Ribble Valley Borough Council
Housing & Development Control

Application no: **3/2019/0569**

Address: **Foxfields Farm, Whalley Road, Hurst Green, BB7 9PN**

Proposal: **Erection of single-storey events/function building. Extension of service road and grass over hardstanding area currently used as a base for a marquee**

DRAWING TITLE
EXISTING & PROPOSED SITE PLANS

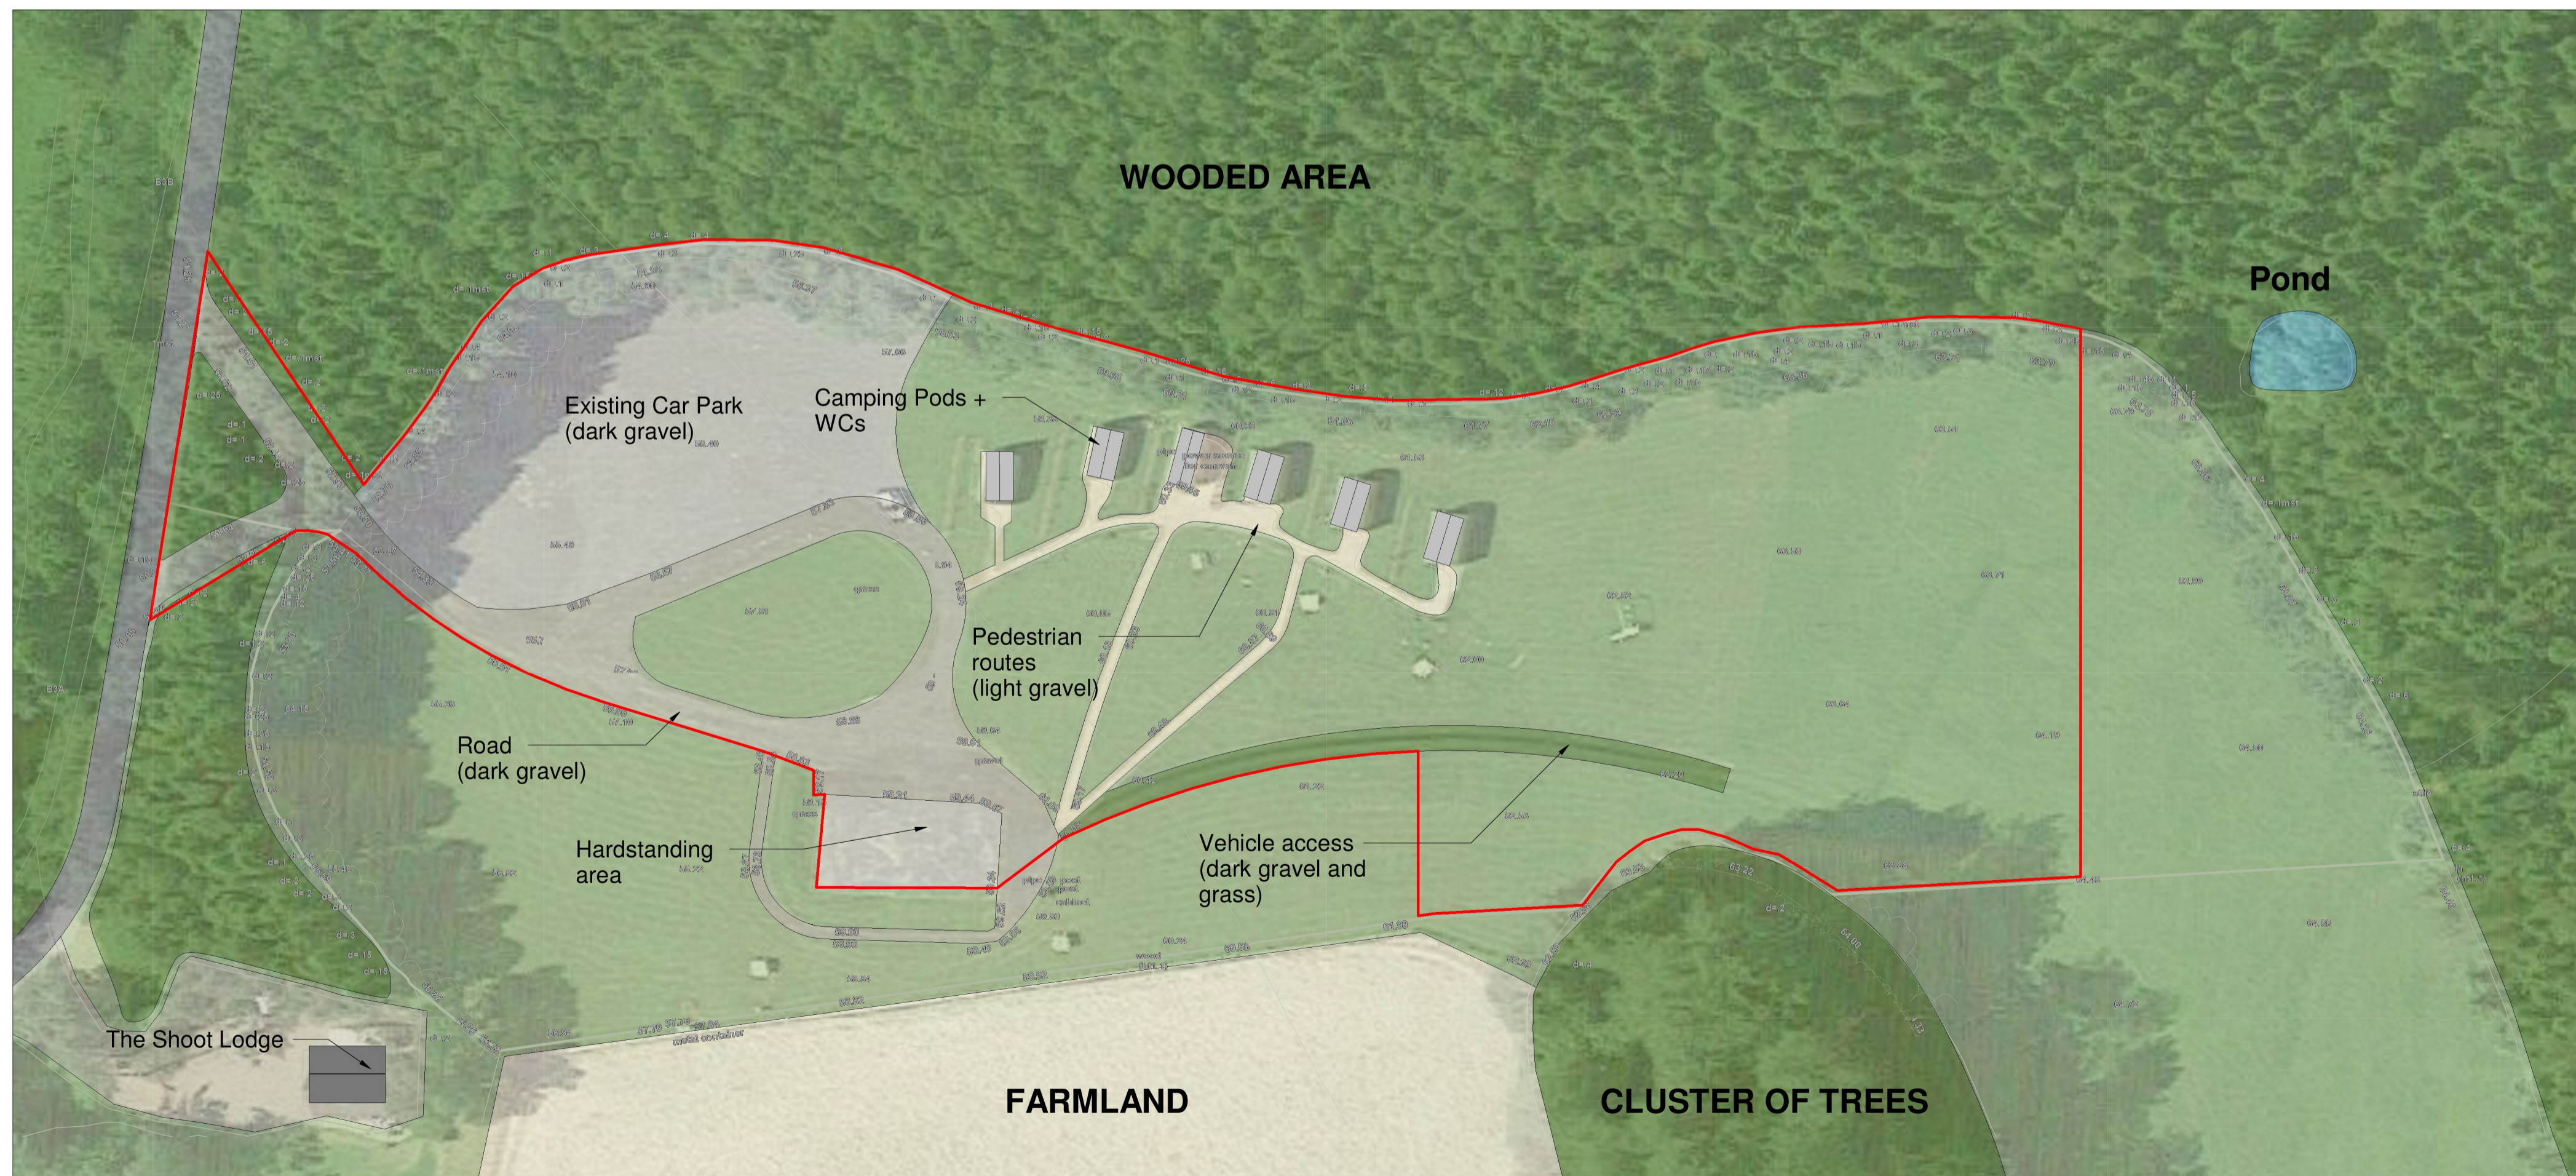
With the potential for 300 parking spaces to be associated with both, the events and glamping business, justification for the potential for such over intensification of use is required. Furthermore, the overspill parking areas have not been demonstrated within the submitted plans.

I would ask that clarification is provided with regards to the potential 300 parking spaces and why there would be such a requirement, also a swept path analysis is required for the associated coaches and articulated Lorries.
